Charlotte Department of Transportation

Memorandum

Subject: Rezoning Petition 08-064: Located on the west side of Frazier Avenue between West 5th Street and Martin Street (revised 5/27/08)

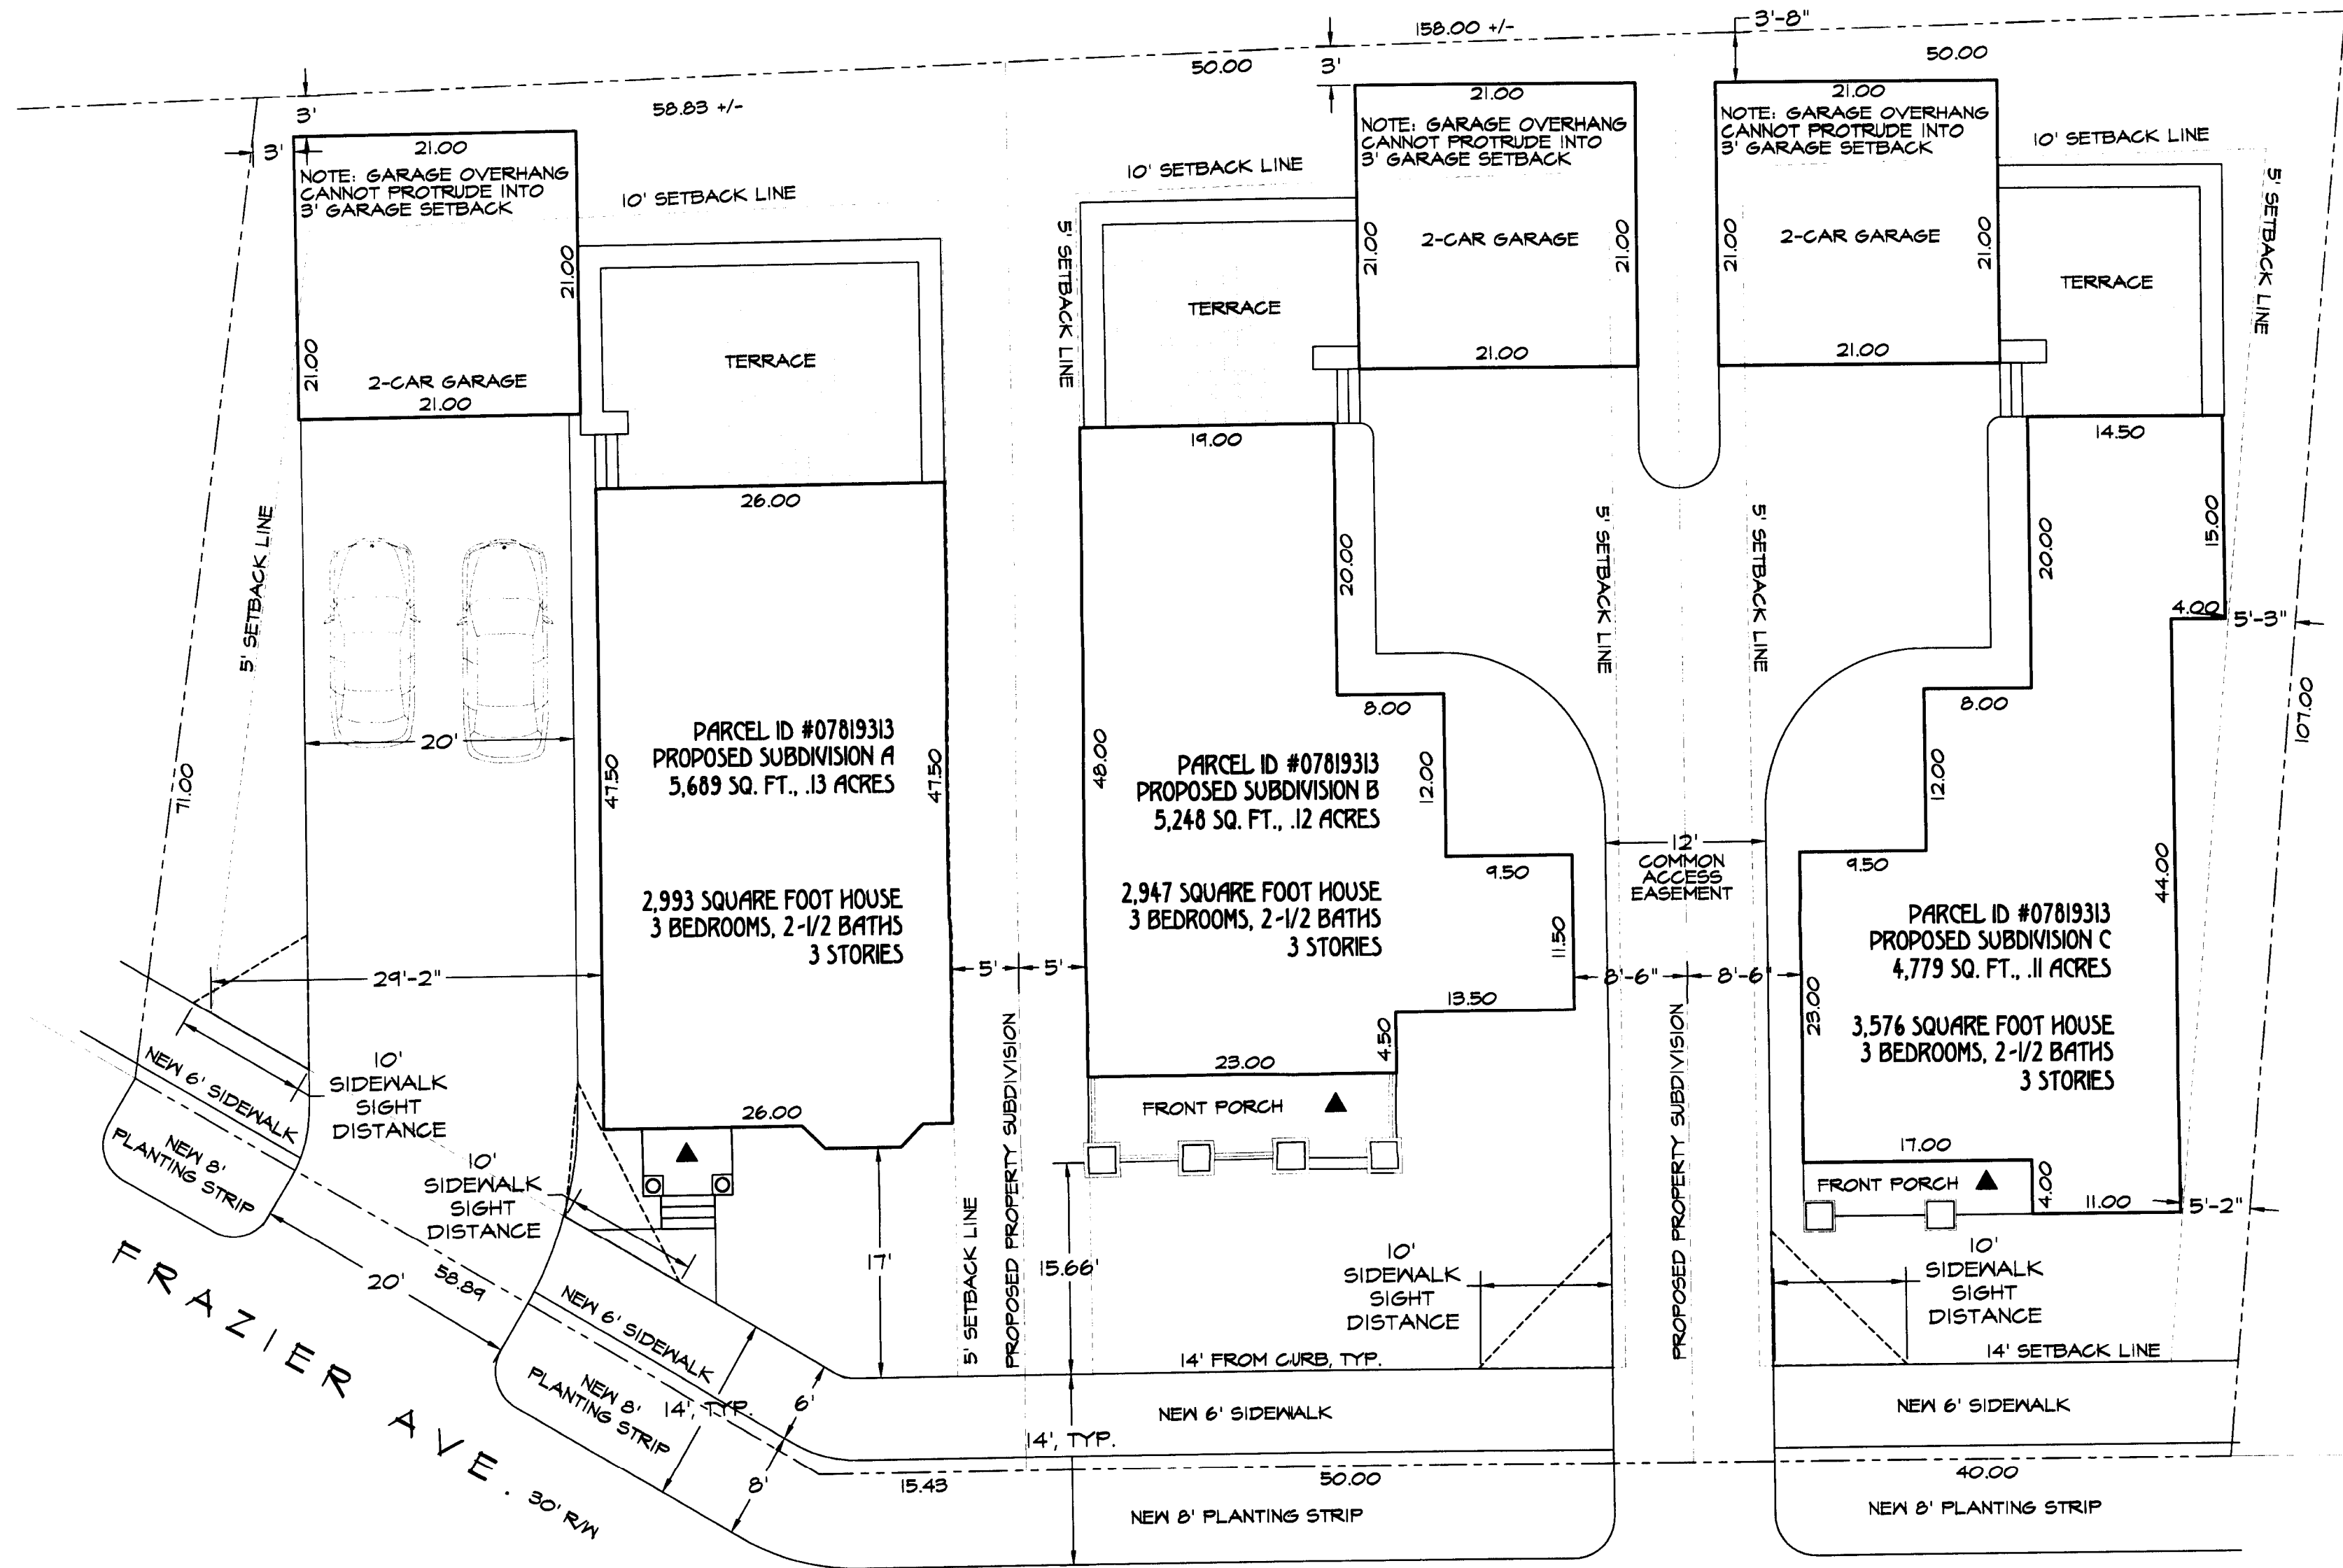
3. At least a 20-foot offset needs to exist between the back-of-sidewalk and the front of each garage. The 20-foot space is necessary to provide enough storage for a vehicle without blocking the public sidewalk. None of the driveways on sheet RZ-2 (Frazier Avenue) meet this requirement. (*Previous review comment*)
